**FURTHER COMMENTS RELATING TO PLANNING APPLICATION FOR ERECTION OF TWO STOREY SIDE EXTENSION, SINGLE STOREY FRONT/REAR EXTENSION, FIRST FLOOR BALCONY AND ASSOCIATED ALTERATIONS**

**MOORLANDS CRICKET CLUB, MIRFIELD MEMORIAL PARK, HUDDERSFIELD ROAD, MIRFIELD, WF14 8AE**

**LPA REF: 2025/90956**

**Pre-Development Plan
Baseline Map**

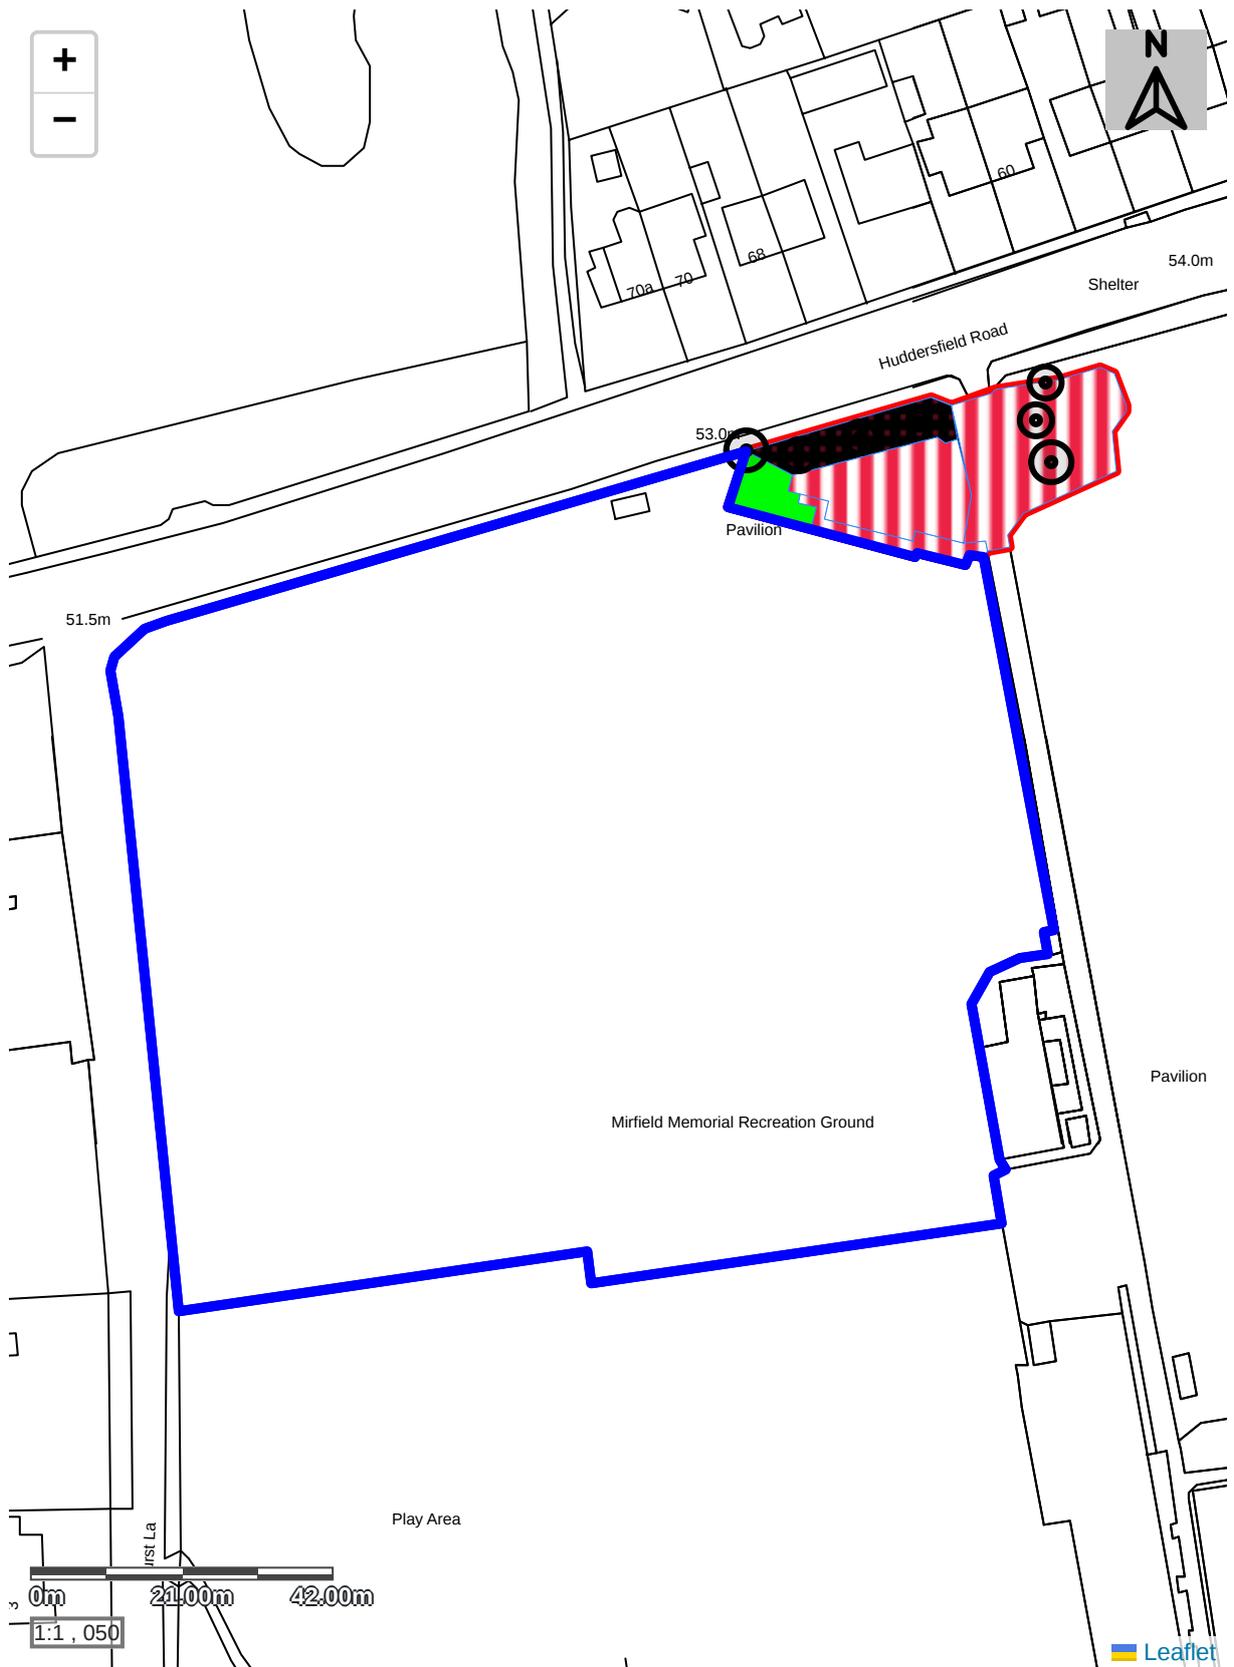
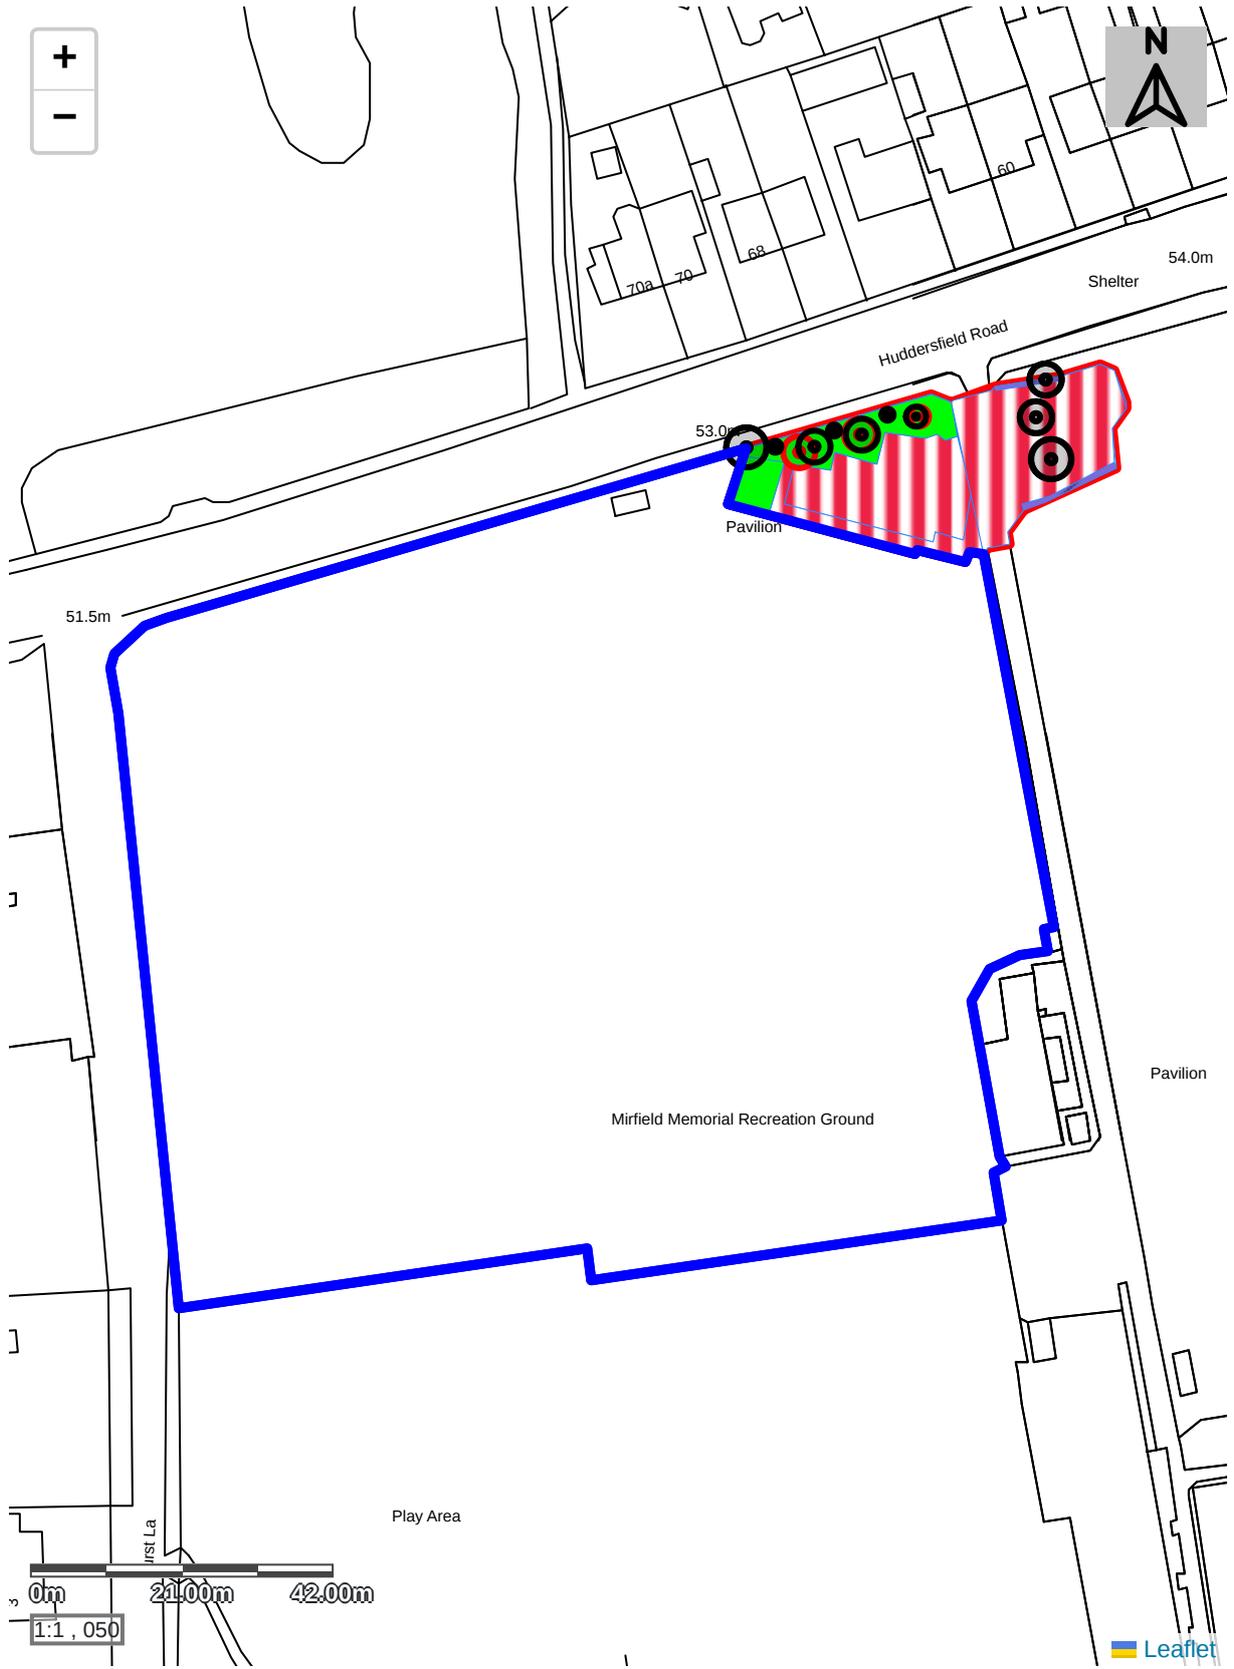
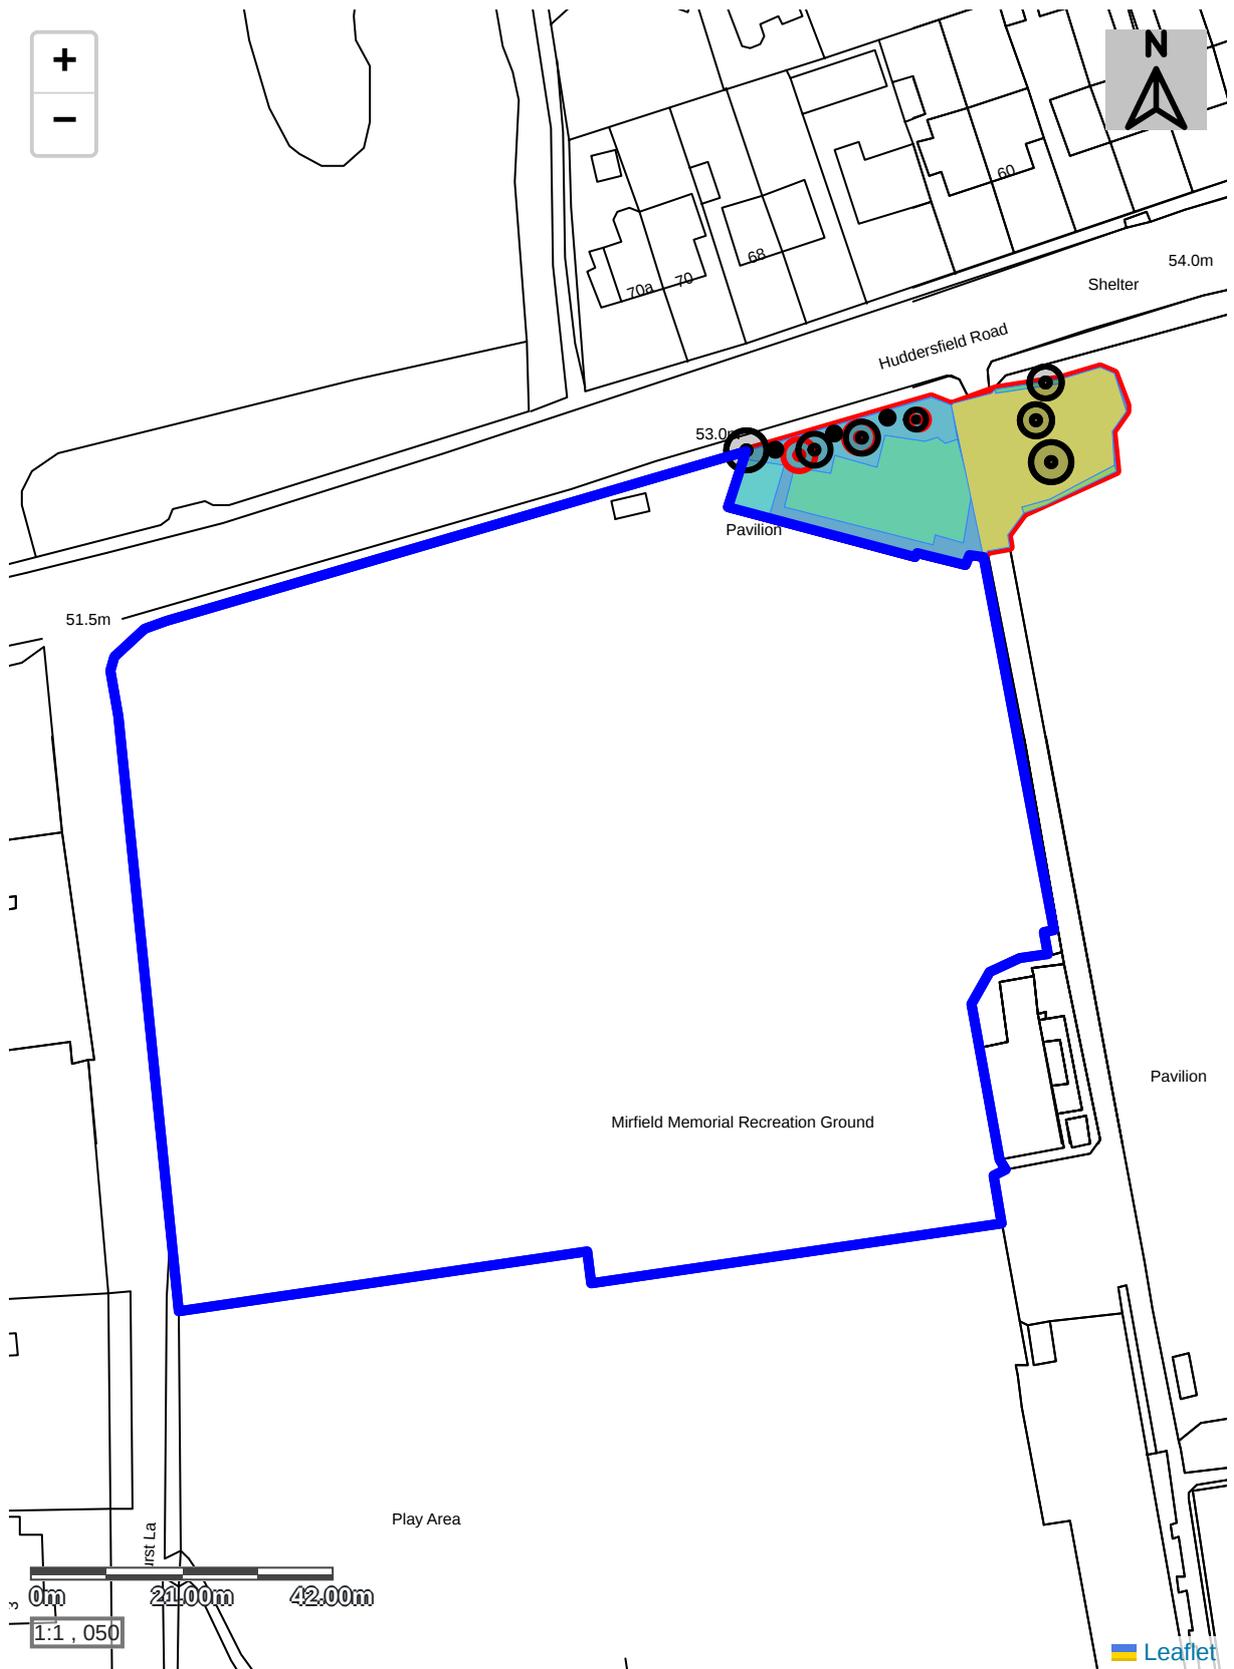
In our original objection letter, we stated that in accordance with Schedule 7A of the Town and Country Planning Act 1990 (inserted by the Environment Act 2021) the felled trees should be considered when the pre-development biodiversity value of the onsite habitat is calculated. This has not been done. The applicant's biodiversity net gain Small Sites Metric states that there are only 7 trees pre-development. However, this figure only includes the remaining trees onsite and does not include the felled trees as indicated in the Tree Constraints Plan extract below.

The Small Sites Metric also states that 4 trees will be retained but not enhanced, and that 10 new trees will be planted post development. However, it is unclear from the Proposed Landscaping Plan which

of the remaining trees are to be retained and which trees are to be removed. Furthermore, the Proposed Landscaping Plan is not clear in respect of the 10 new trees to be planted as it shows 3 proposed Poplar trees and 10 proposed bushes / small trees which equates to 13 trees! The Small Sites Metric also states that the trees planted post development will include 3 small trees, 1 medium tree, 4 large trees and 2 very large trees, which again doesn't correspond with the information shown on the Proposed Landscaping Plan.
